An
Bord
Pleanála

Inspector's Report

ABP-319448-24

Development	8 no. turbine wind farm development and associated works
Location	Land within the townlands of Clonmellon, Kilrush Upper, Kilrush Lower, Newtown, Ballinlig, Carnybrogan, Cavestown and Rosmead, County Westmeath and Galboystown, Co. Meath. (www.knockanarraghwindfarmsid.ie)
Planning Authority	Meath County Council and Westmeath County Council
Planning Authority Reg. Ref.	N/A
Applicant(s)	Knockanarragh Wind Farm Ltd.
Type of Application	S37E, Planning & Development Act 2000 (as amended).
Prescribed Bodies	Irish Water, TII, Failte Ireland, Ministry of Defence and Irish Aviation Authority
Observer(s)	P. & A. Dalton. E. Carr. N. Tobin. S. & M. Kenny. S. Murray. T. Ni Fhionnain.

Typical / potential hardstanding layout
Scale 1:1,000

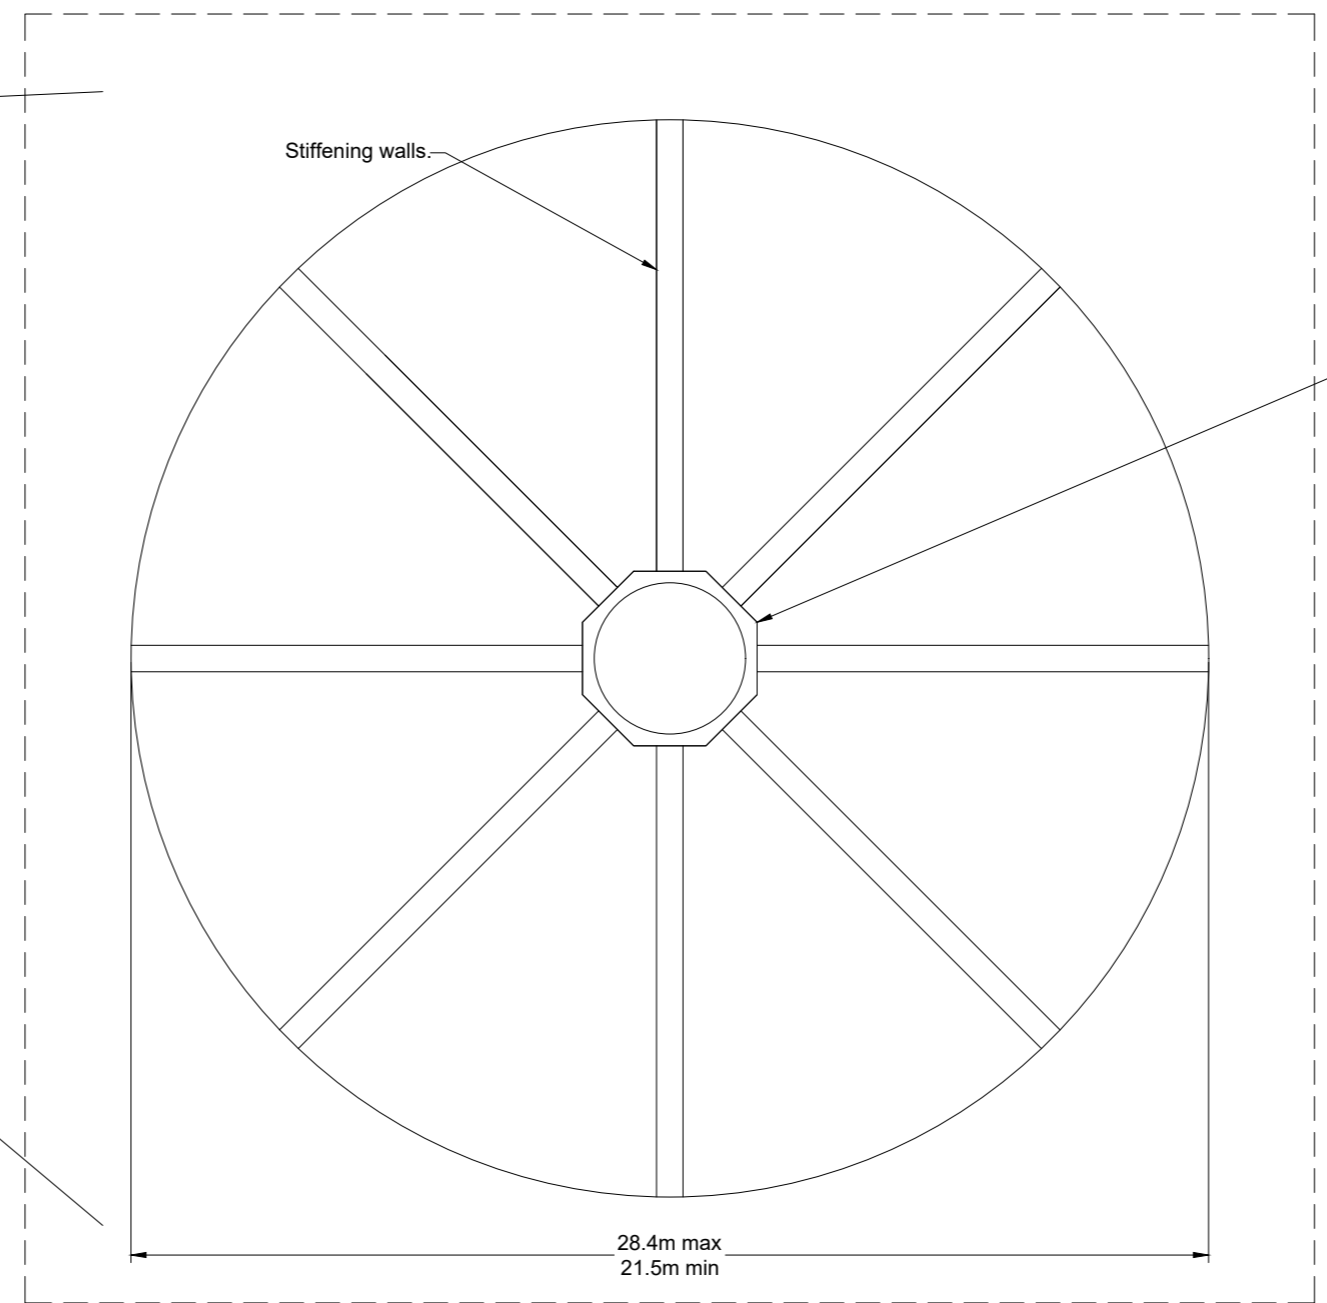
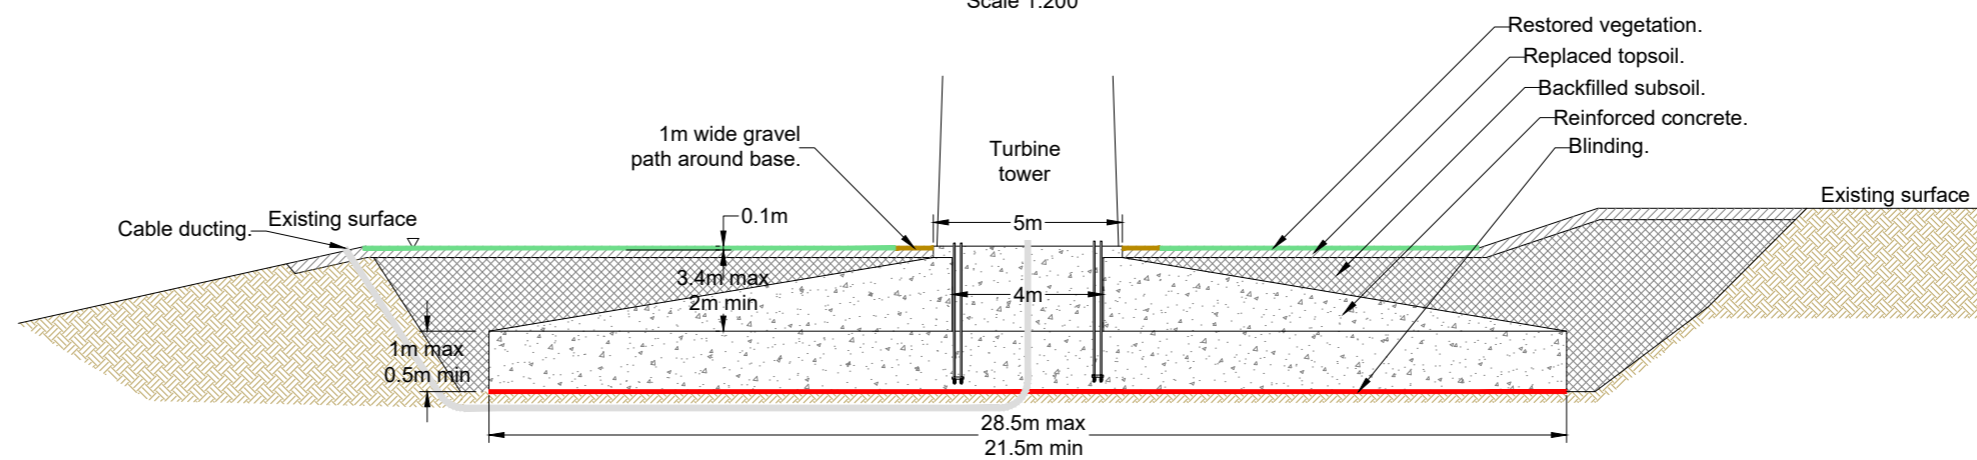
- The construction of *temporary hardstands, main crane hardstands and permanent turbine foundations* with sizes to vary with turbine model used (Drawing no. ABP-314271-22.PL07, Turbine Foundations and Crane Hardstanding Layout). The Board should note that in section 2.41 of the EIAR it is stated that turbine foundations will be 2.5m in depth. However, in the above drawing, turbine foundation depth is shown as 4m. Crane hardstands will be founded on solid ground and have a 0.5m thick engineered granular fill to provide a flat even surface for the crane.
